October 17, 2019

Re: Dripline (Biergarten)
13202nd St NW
Traffic Circulation Layout
Engineer's/Architect's Stamp 06-14-2019 (J14D046)

Based upon the information provided in your submittal received 07-26-2019, the above referenced plan cannot be approved for Building Permit until the following comments are addressed:

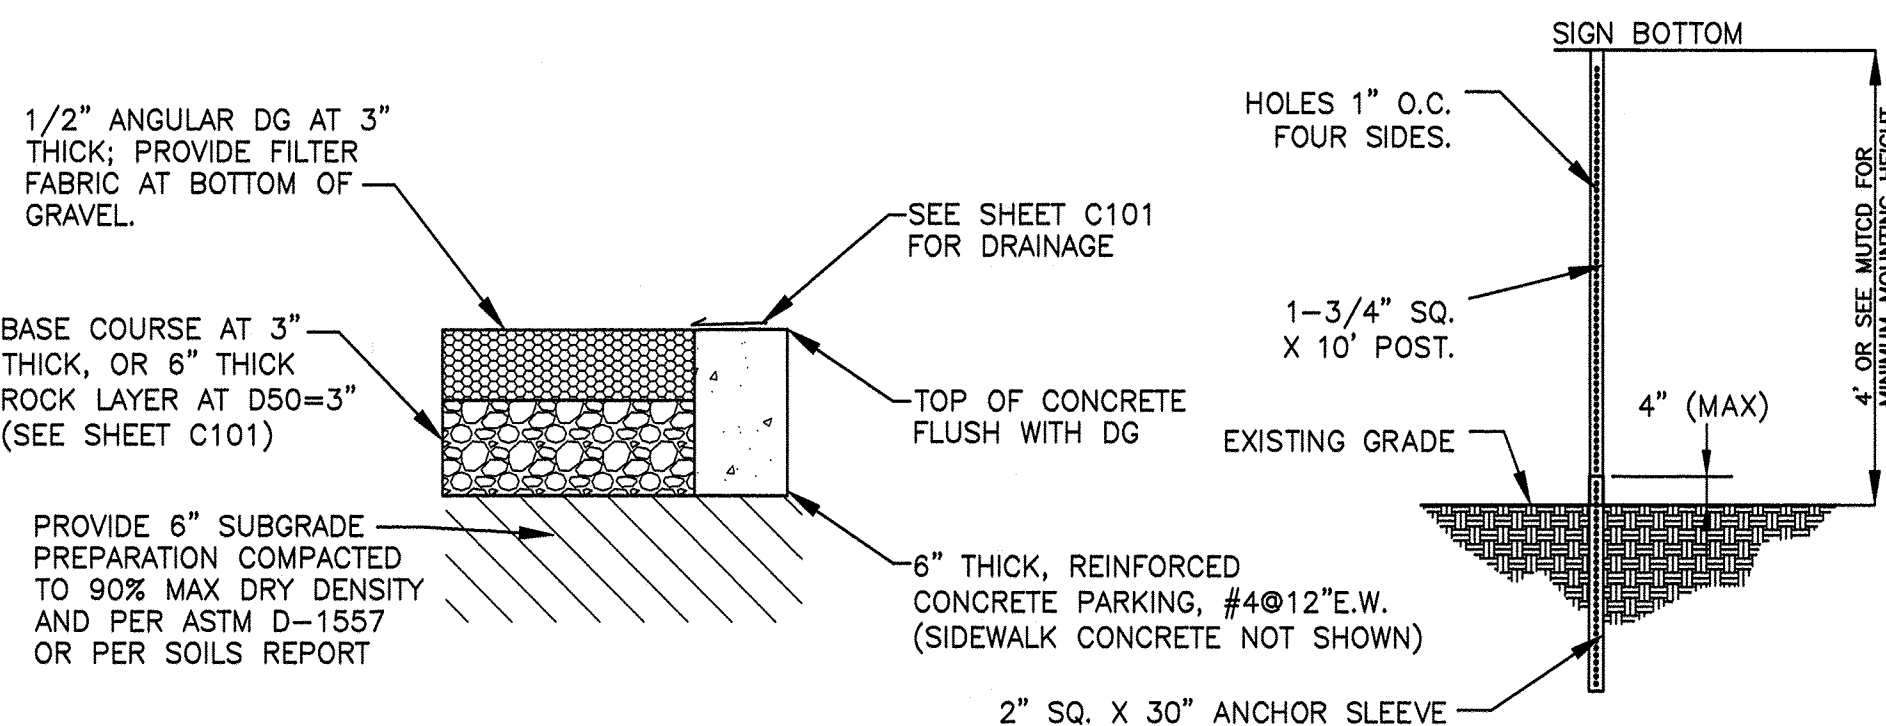
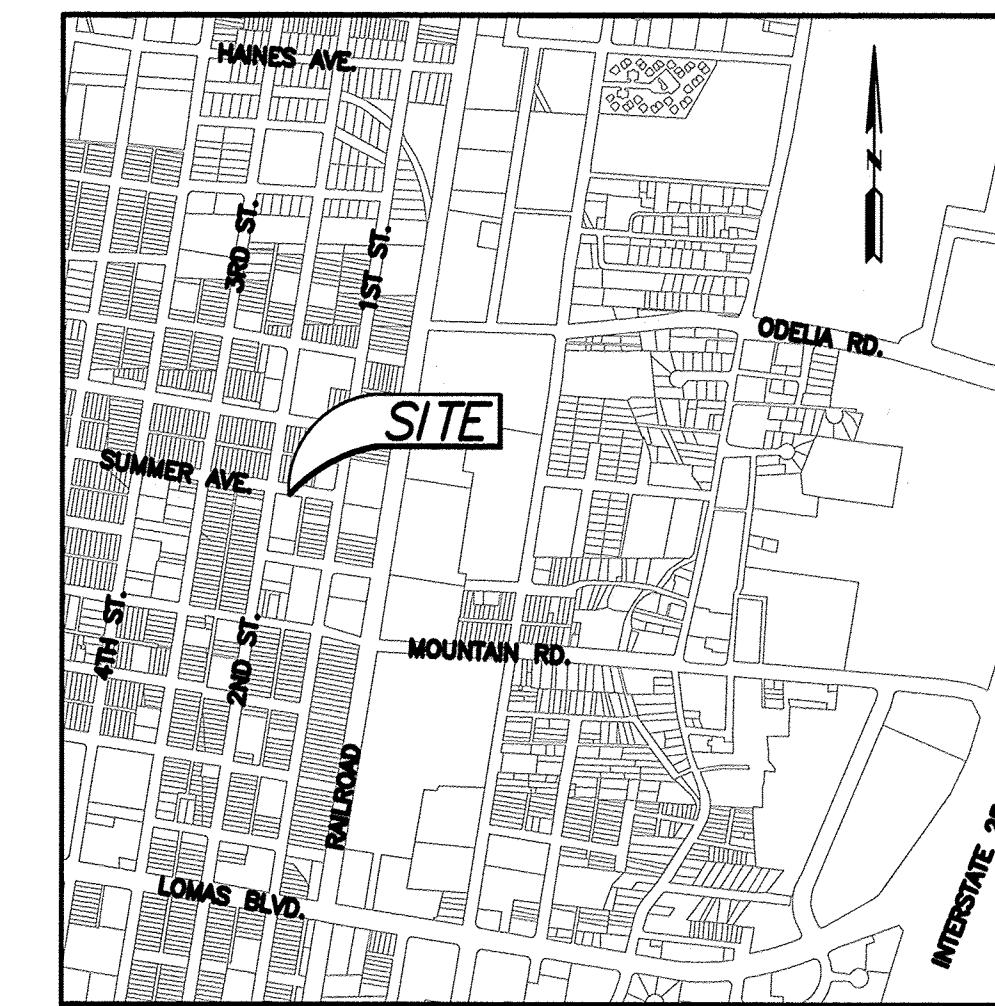
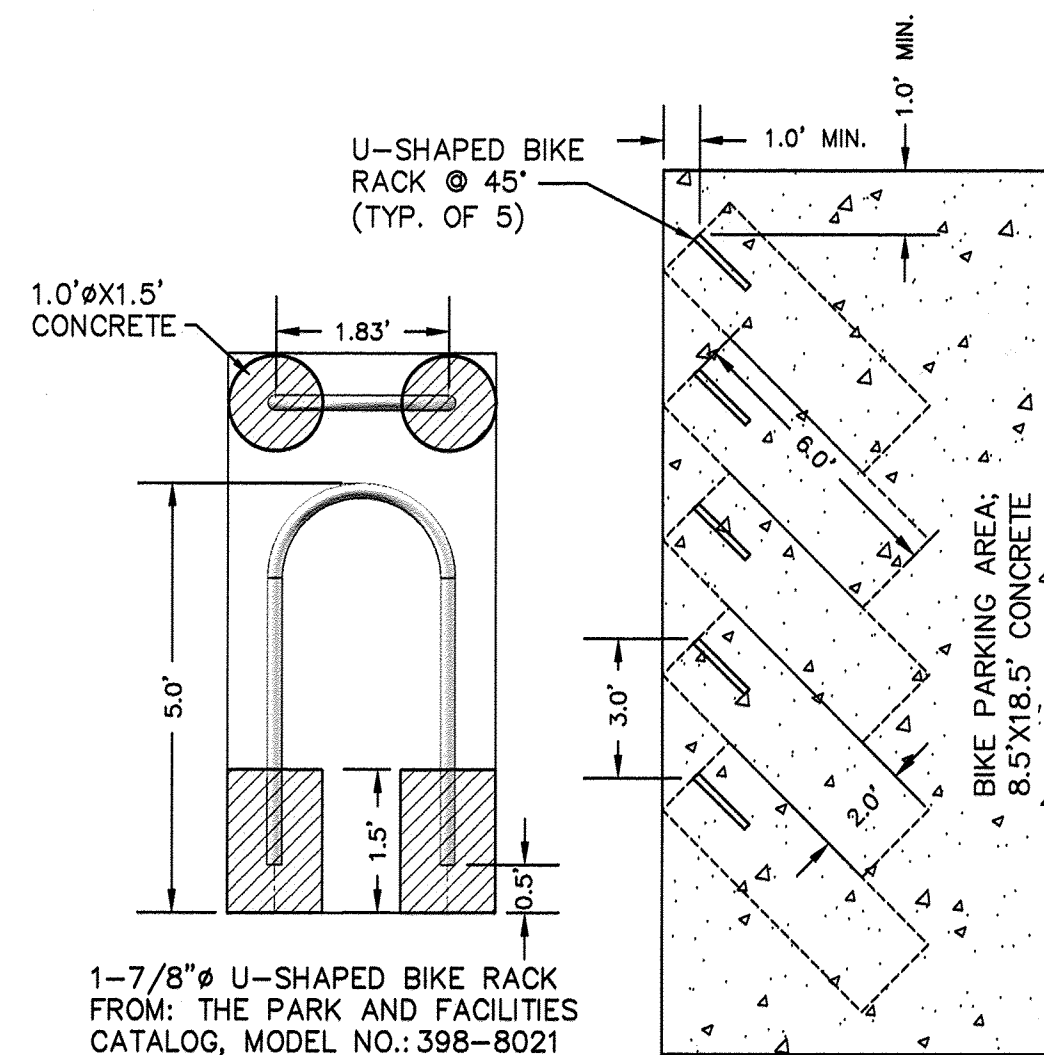
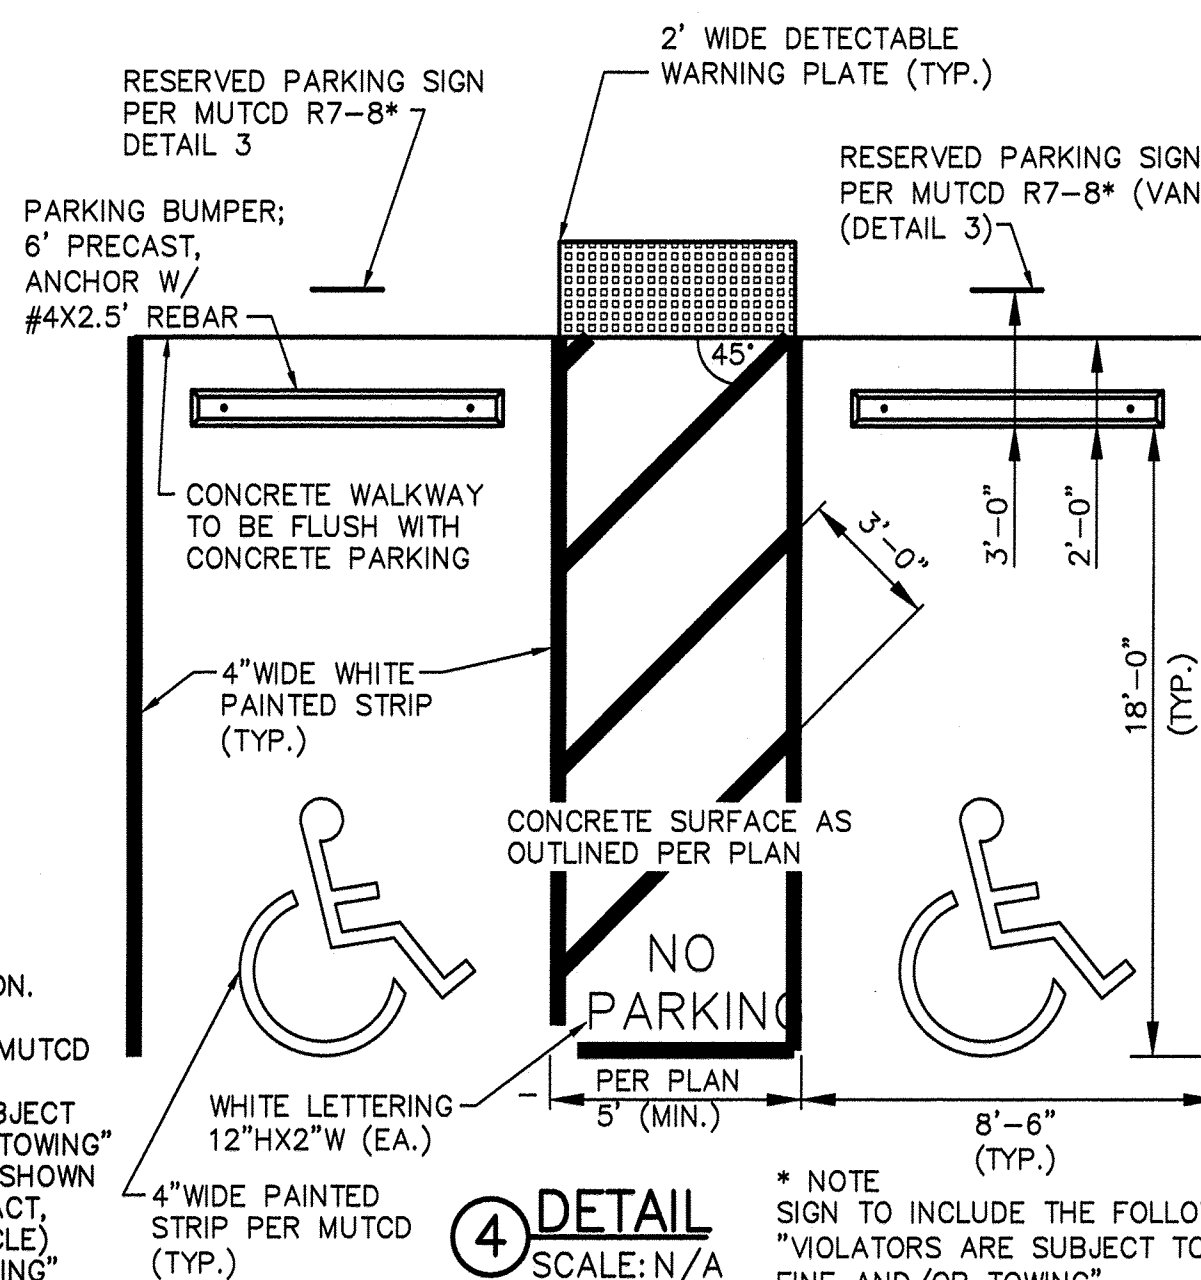
1. The parking calculation table:
 - a. 17 shared and 27 shared : please clarify what buildings are sharing these parking spaces and explain how this shared parking is acceptable.

- b. For designated spaces such as car pool, those spaces needs to have signs their own signs and be designated.
 - c. Label the compact parking spaces by placing the words "**COMPACT**" on the pavement of each space.

2. Bicycle comments from last time haven't been met:
 - a. All bicycle racks shall be designed according to the following guidelines:
 - i. The rack shall be a minimum 30 inches tall and 18 inches wide.

- ii. The bicycle frame shall be supported horizontally at two or more places. Comb/toaster racks are not allowed.
 - iii. The rack shall be designed to support the bicycle in an upright position. See the IDO for additional information.

- iv. The rack allows varying bicycle frame sizes and styles to be attached.
 - v. The user is not required to lift the bicycle onto the bicycle rack.
 - vi. Each bicycle parking space is accessible without moving another bicycle.

- vii. Bicycle racks shall be sturdy and anchored to a concrete pad.
- viii. A 1-foot clear zone around the bicycle parking stall shall be provided.
- ix. Bicycle parking spaces shall be at least 6 feet long and 2 feet wide.

- 3. provide a copy of refuse approval.
- 4. Remove trees or any type of landscaping from TCL.
